Please ask for: Sian Eggington
Email: sian.eggington@terraquest.co.uk
Telephone: 0121 2341390
Our Ref: FP/182/20/HH
Your Ref:
Date: 19th October 2020

Application for Planning Permission for Works or Extension to a Dwelling

Development: Single storey rear extension to replace existing conservatory with revised roof to existing single storey extension, first floor rear extensions, single storey glazed canopy to south side elevation

Location: Gulls 7 First Avenue Felpham PO22 7LG

Job No: 3249
Dwg No: P_02

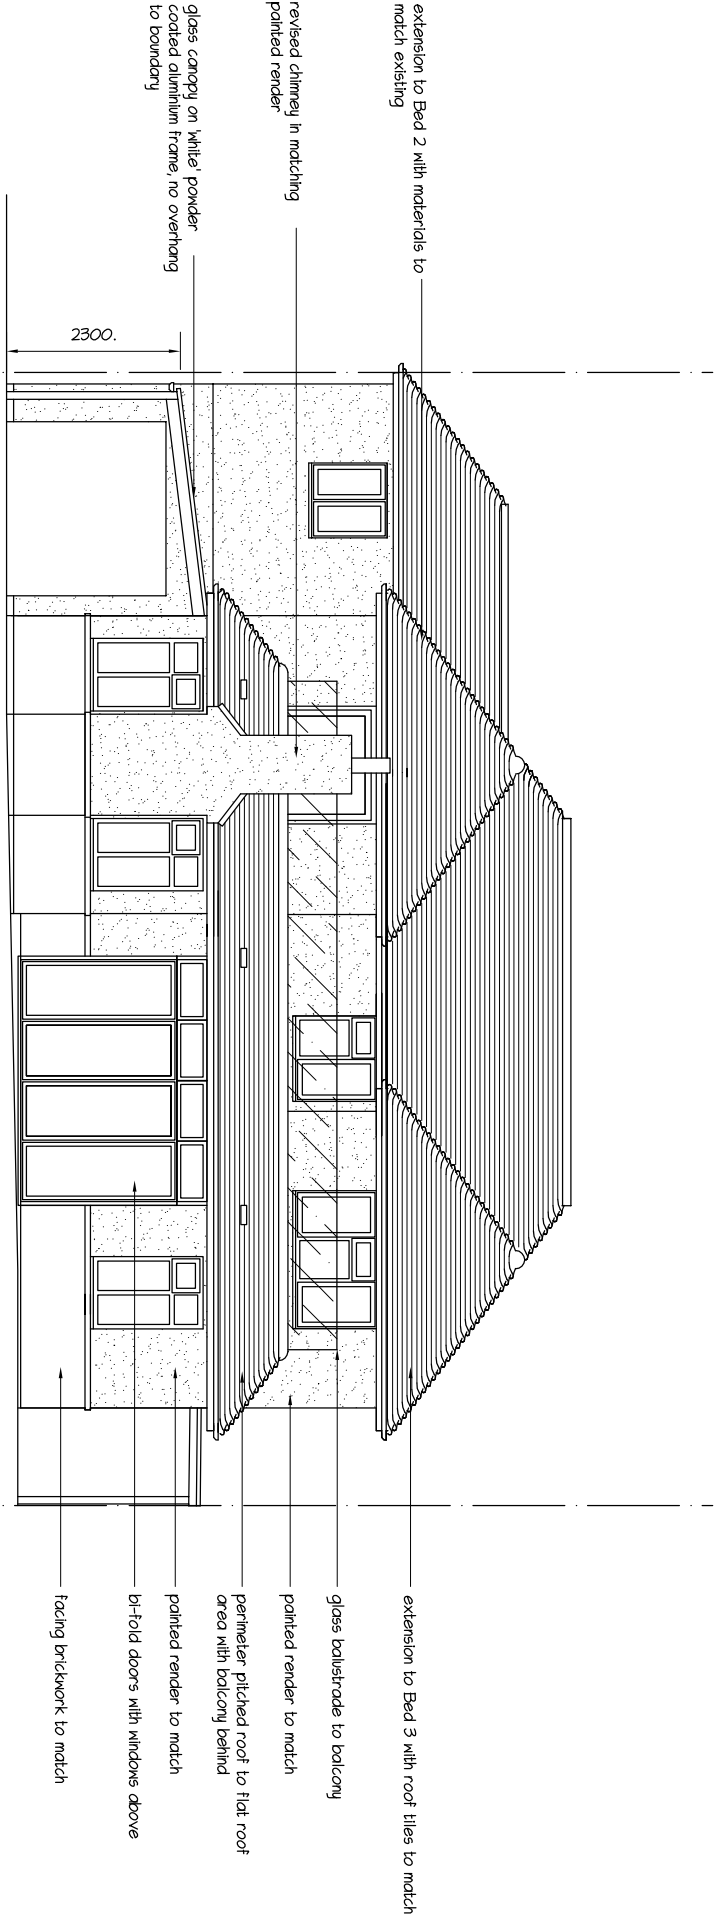
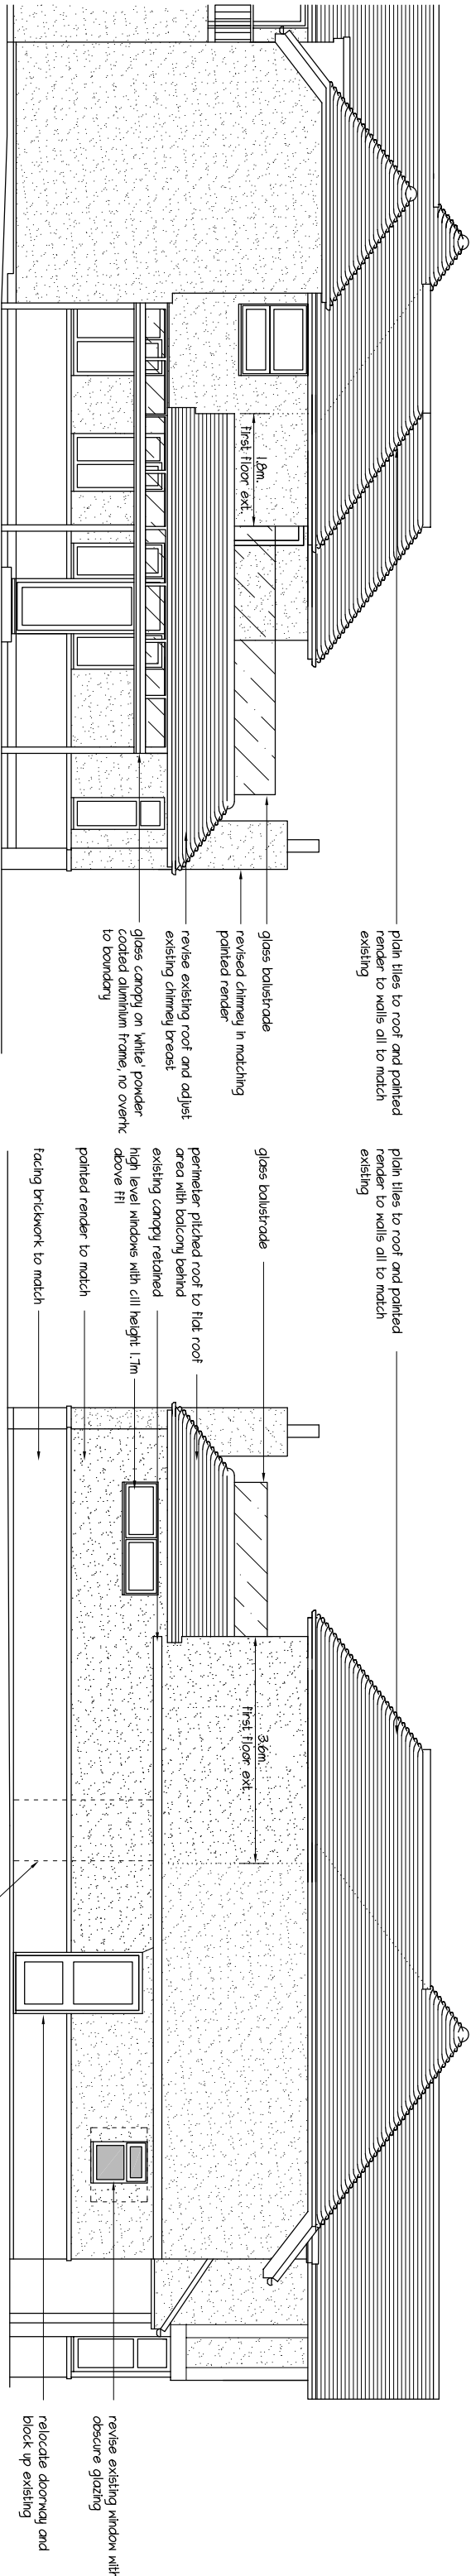
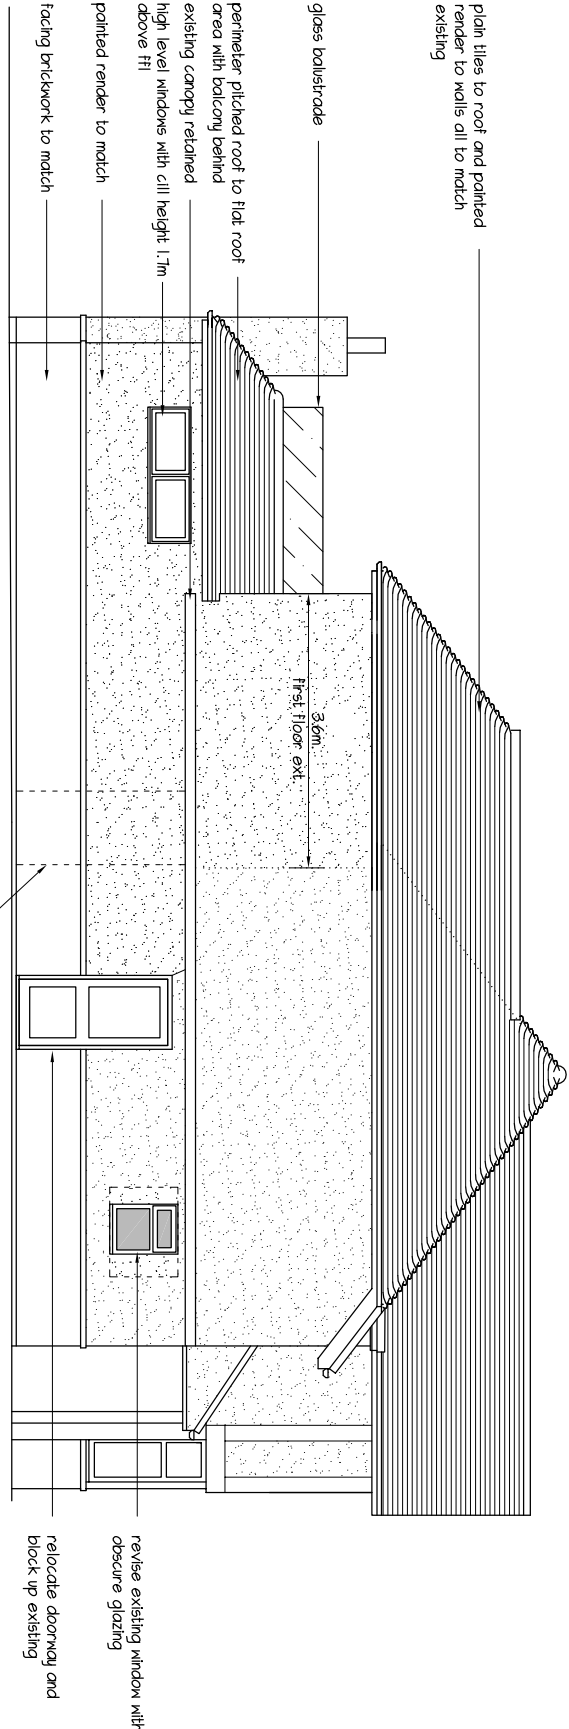
Other Side Elevation: Please provide the other side elevation for this proposal.

Block

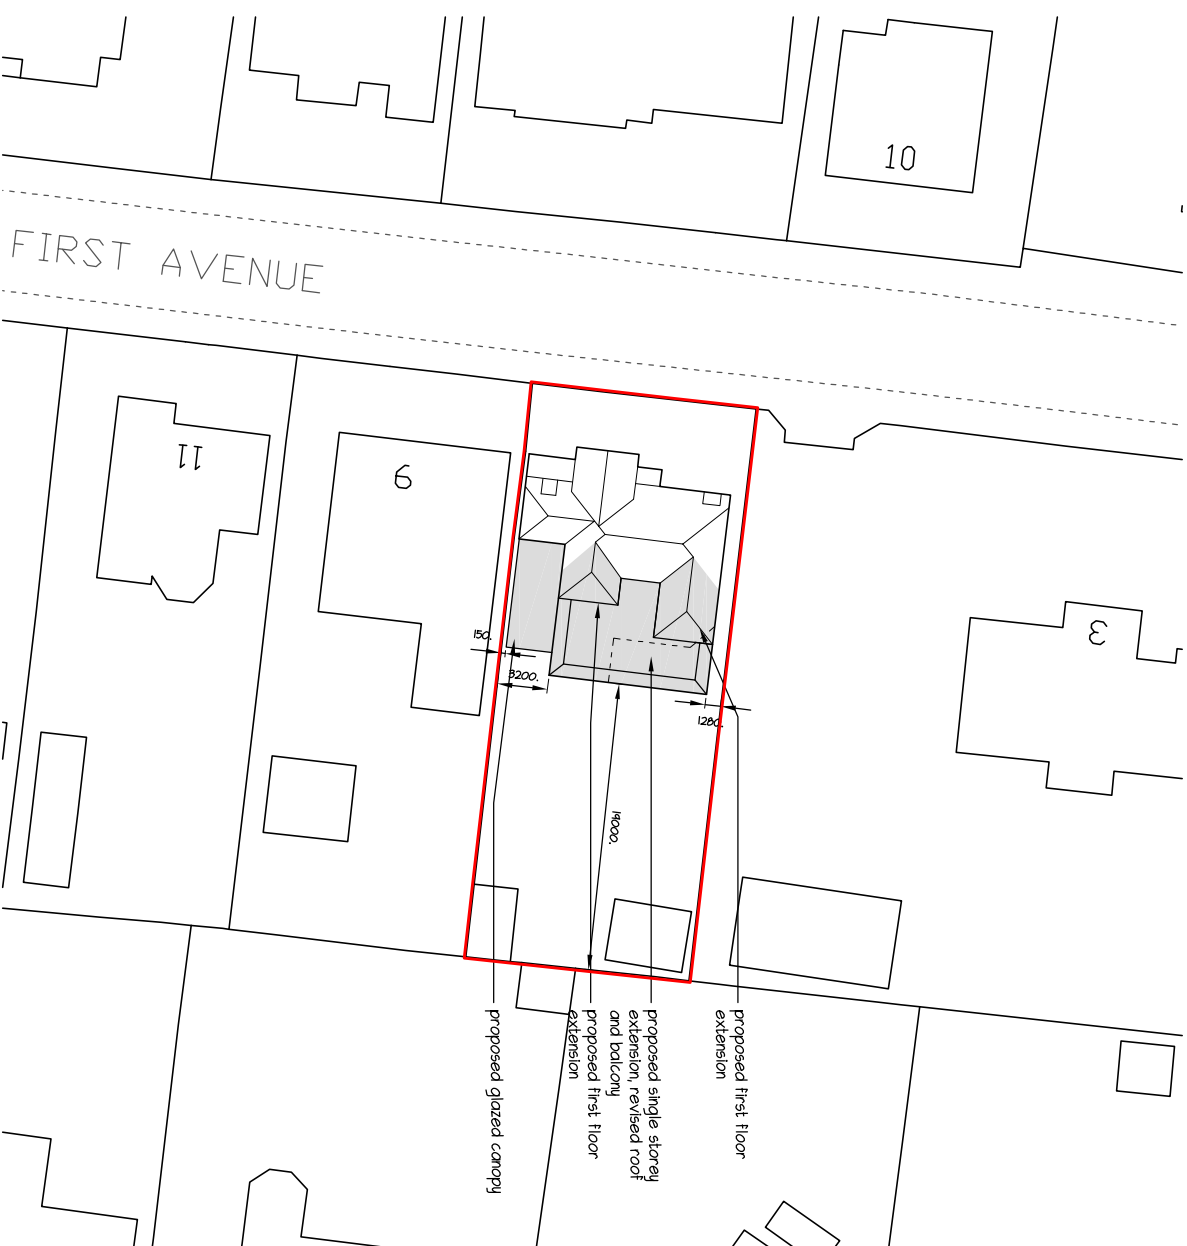
Dimensions: You are required to include dimensions from the proposed extension to all site boundaries on the block plan.
